Our ref: Birriwa Solar Farm (SSD-29508870)

Subject: Request for Additional Information

I refer to the Birriwa Solar Farm (SSD-29508870). After careful consideration, the Department is requesting that you provide additional information.

Figure 5.5 R3 Viewshed Analysis

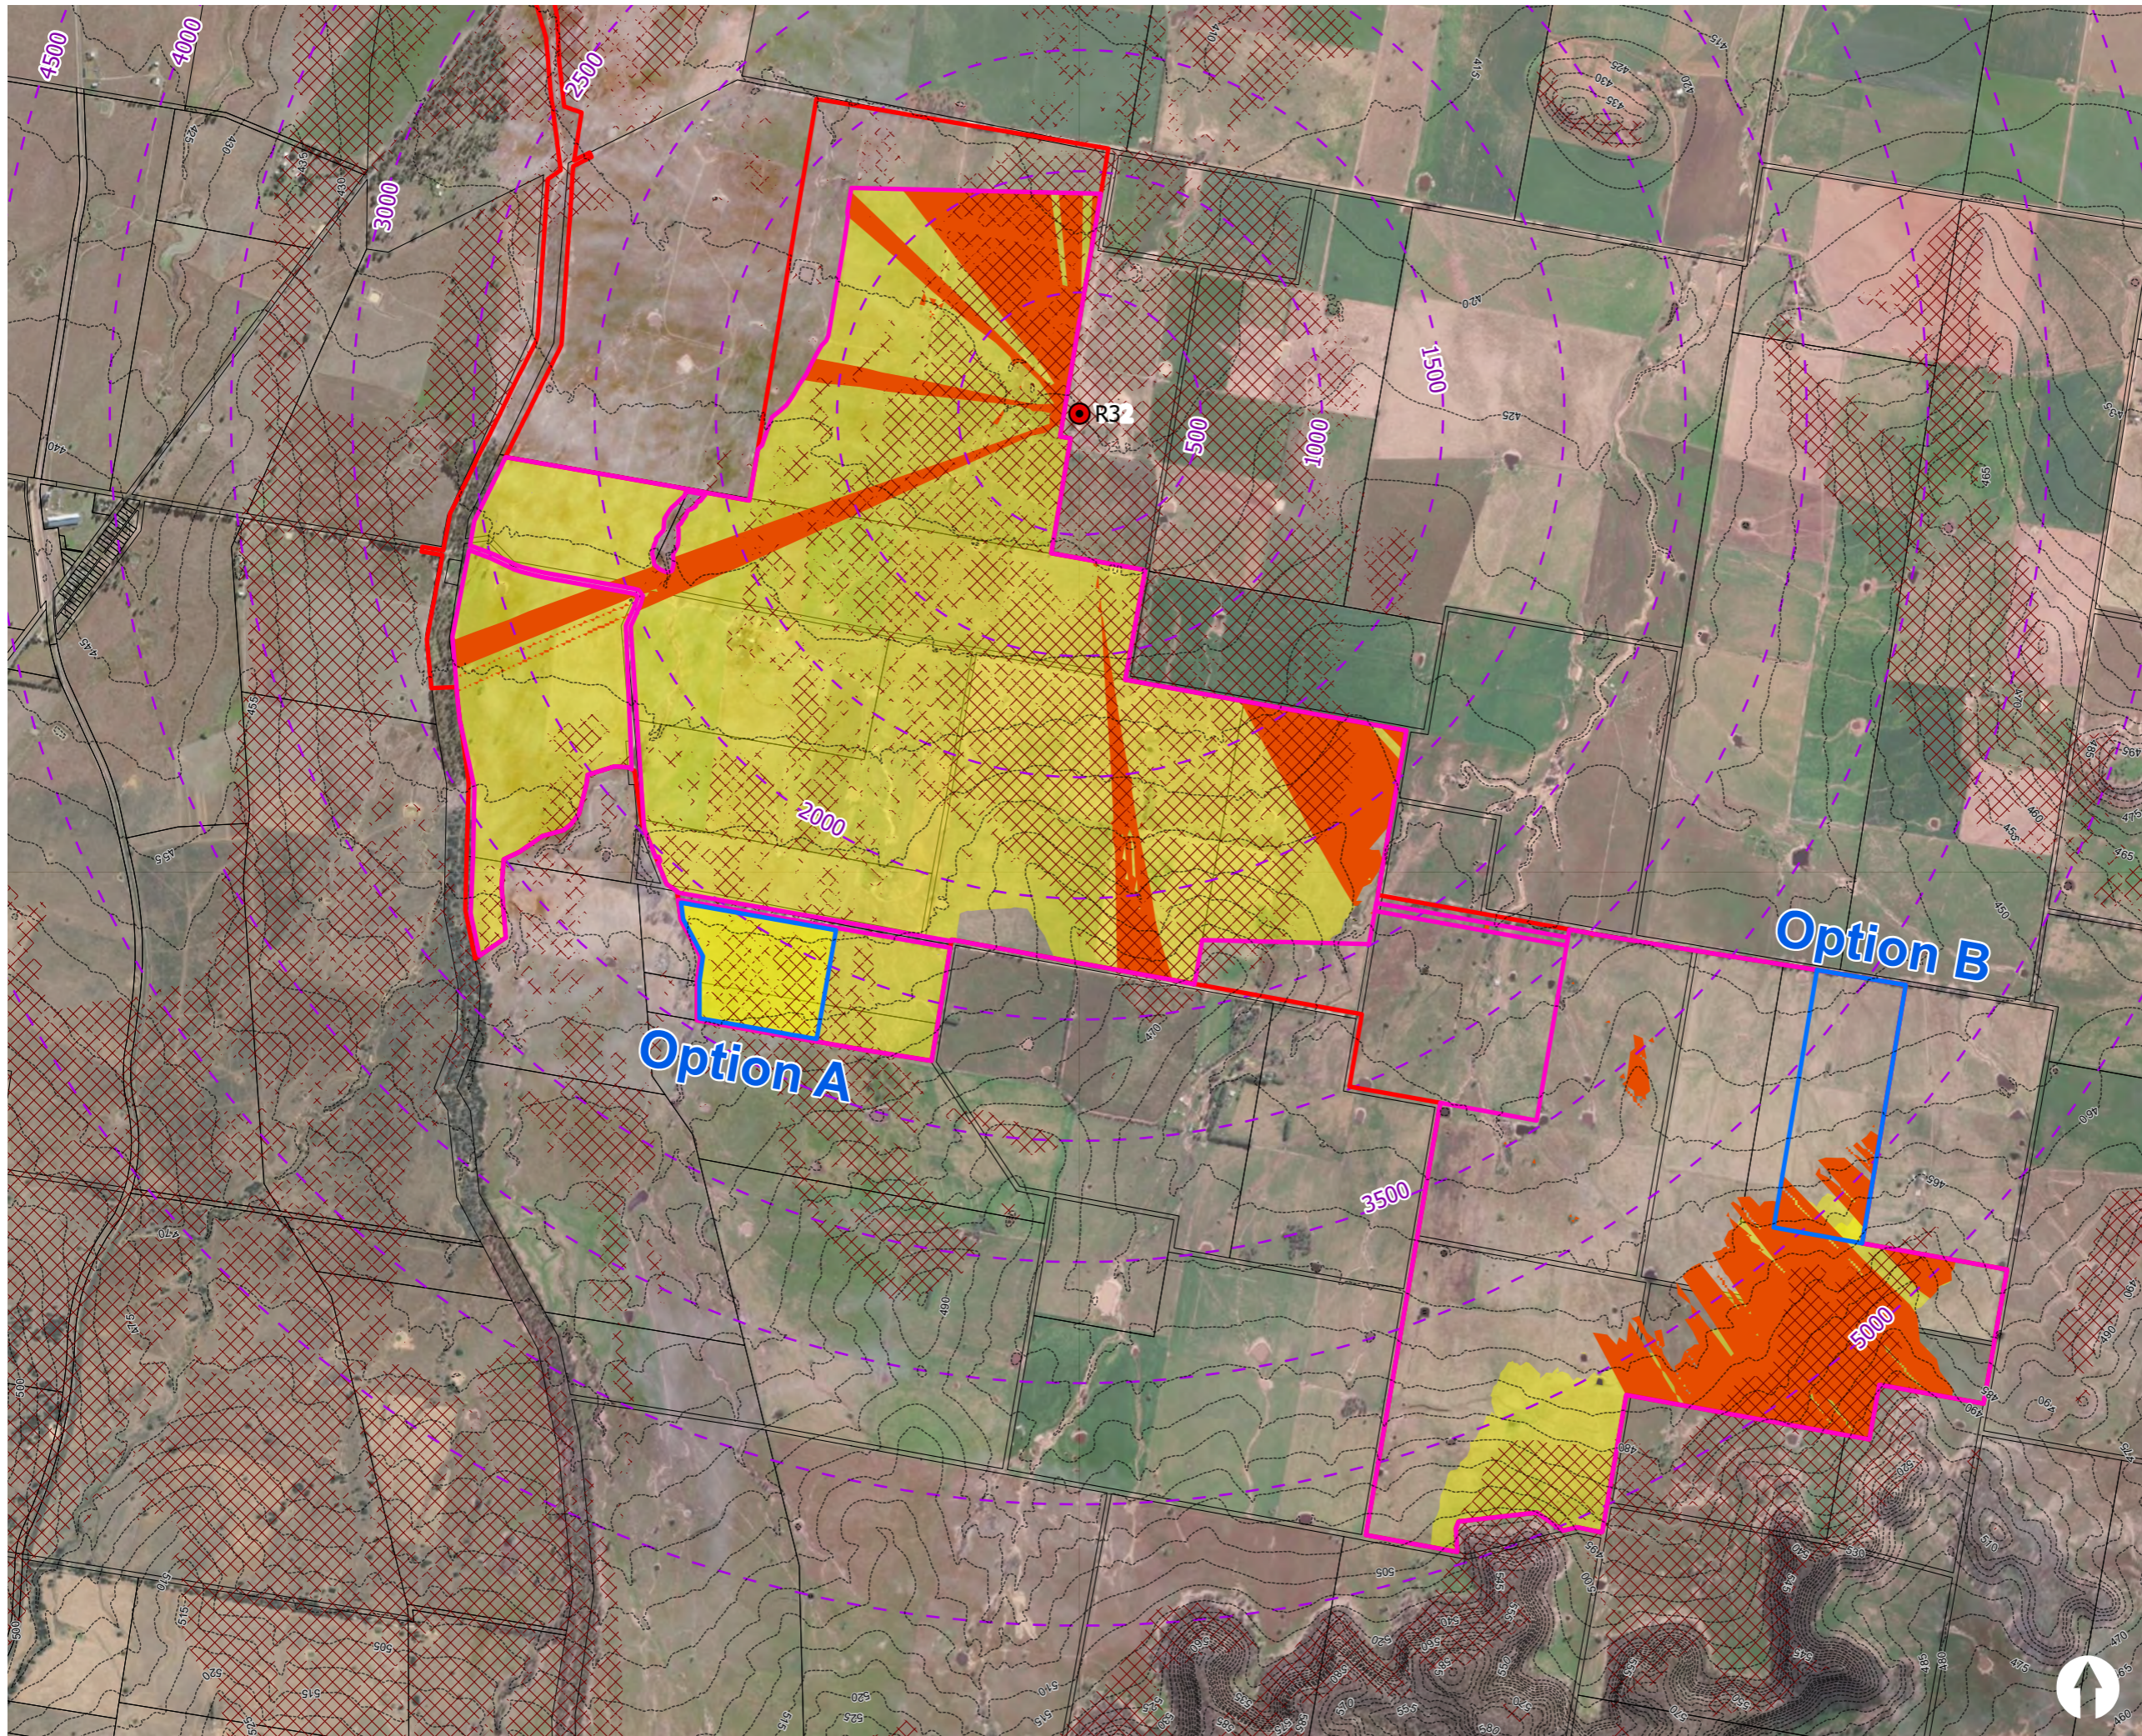
- details of mitigation measures proposed for receiver R03, including evaluation of the residual impacts post-mitigation. If setbacks or screening is proposed, this should be shown clearly in figures; and
- an updated analysis for VP1 with viewshed analysis which aligns with the photomontage, and an updated visual impact rating as discussed.
